Erection of 1 no. 2 bed bungalow following Outline Planning approval AL/7/11/
Land to rear of 31 Meadow Way Westergate Aldingbourne PO20 3QT

**Erection of 1 no. 2 bed bungalow following Outline Planning approval AL/7/11/
Land to rear of 31 Meadow Way Westergate Aldingbourne**

I regret that I am unable to accept your documents as a formal application until the following matters have been resolved :-

PROPOSED GROUND FLOOR PLAN

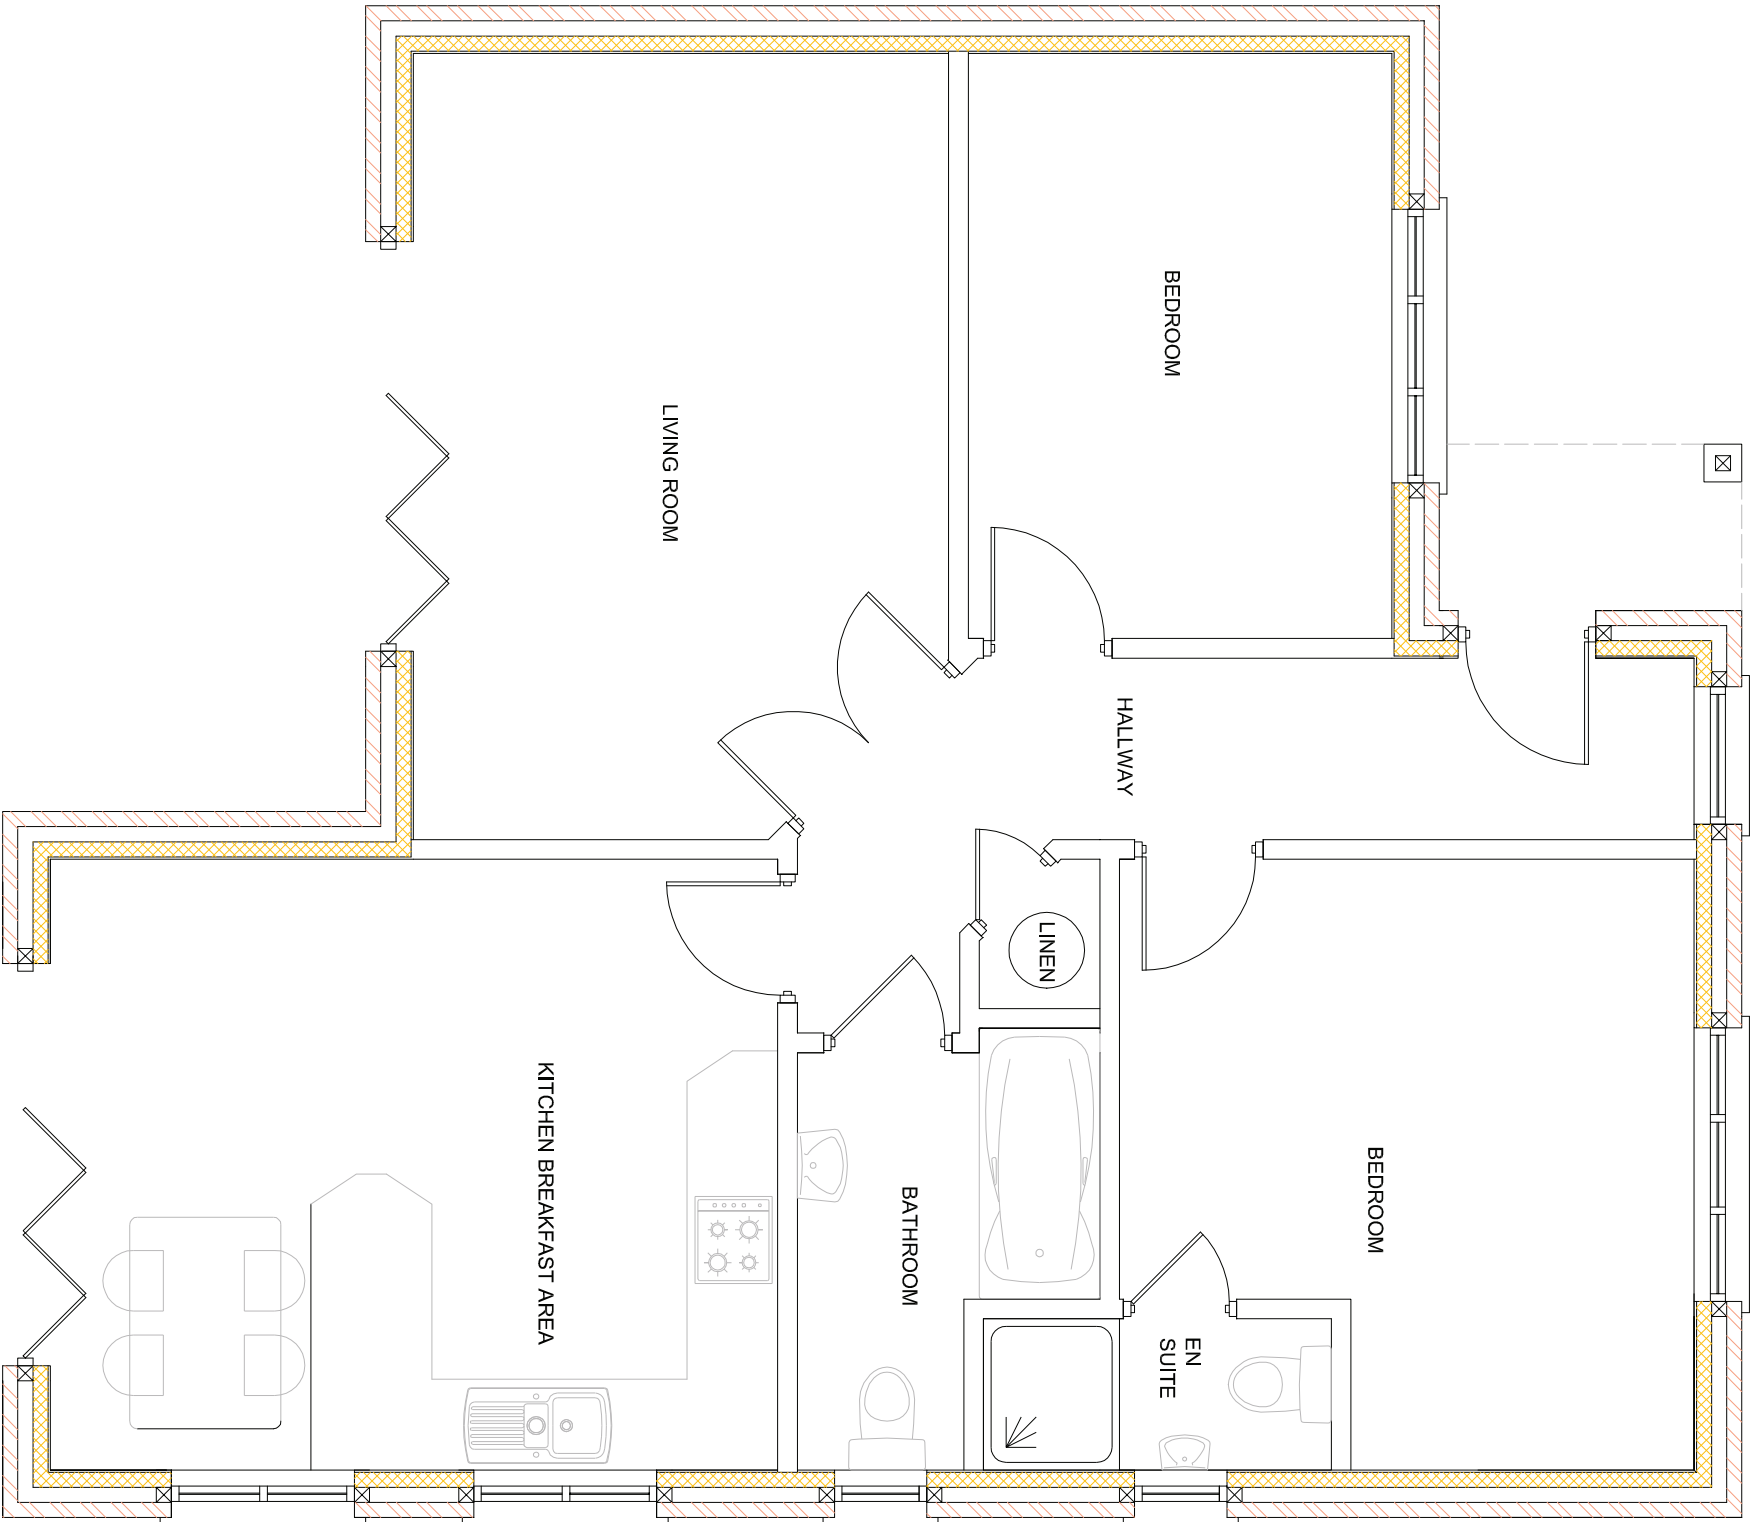
Please provide 1 electronic or 3 paper copies of revised proposed front and side elevations. There is a door shown on the floor plan which is not shown on the front elevation and 4 windows are shown on the floor plan, but the side elevation only shows 3.

EXISTING SITE PLAN - 1/500

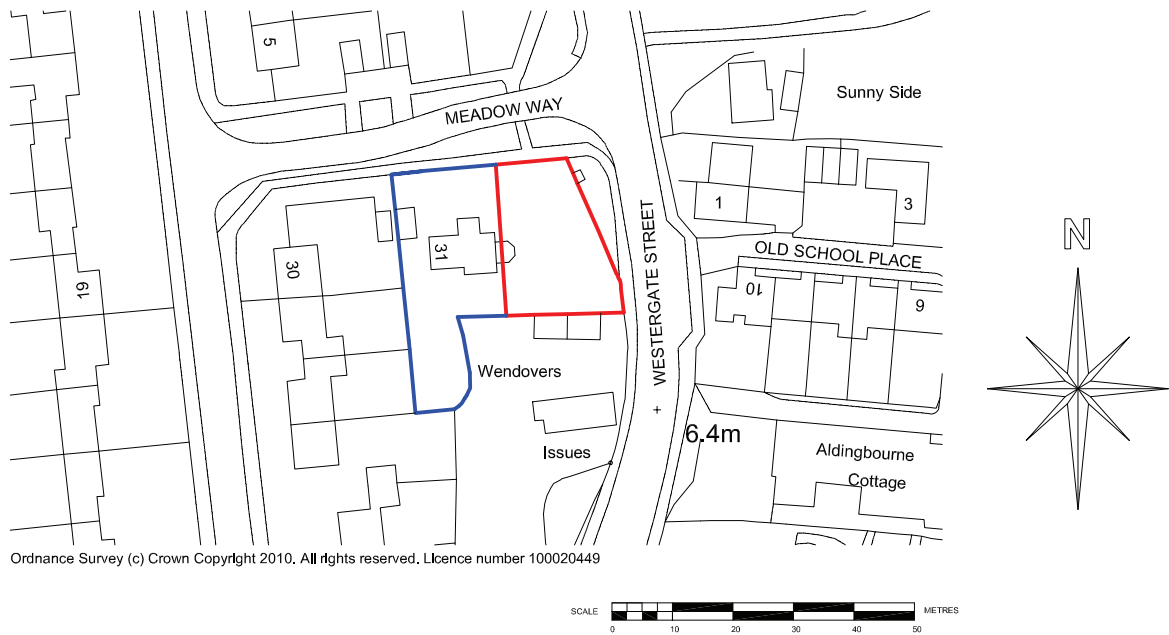
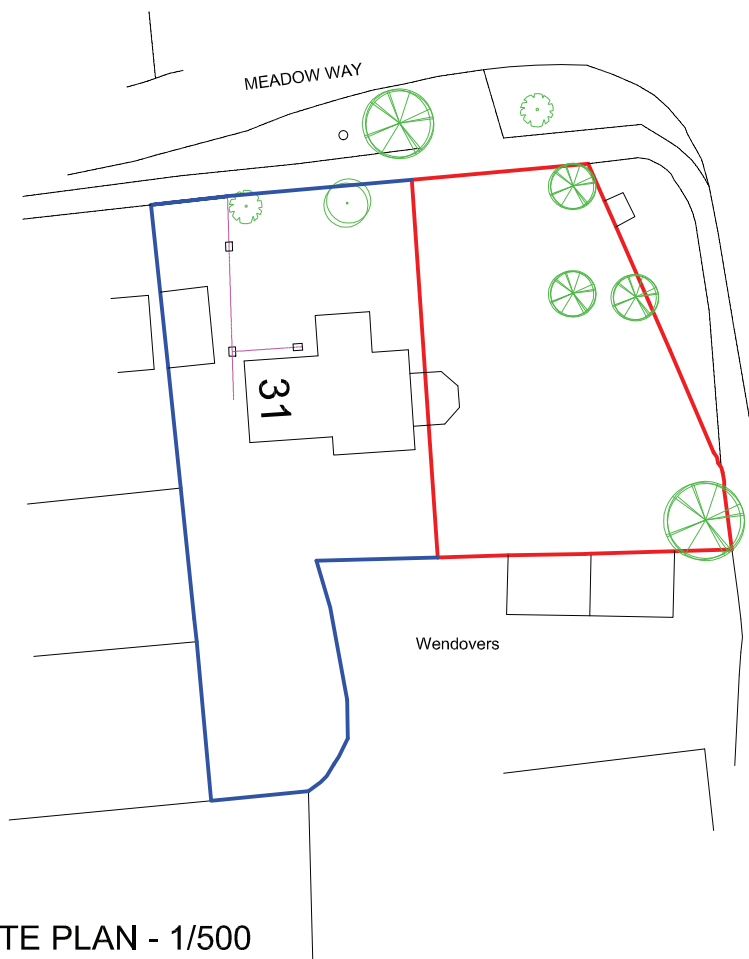
Please provide an existing location plan/site plan to show the blue and red edging to match the proposed location/site plan.
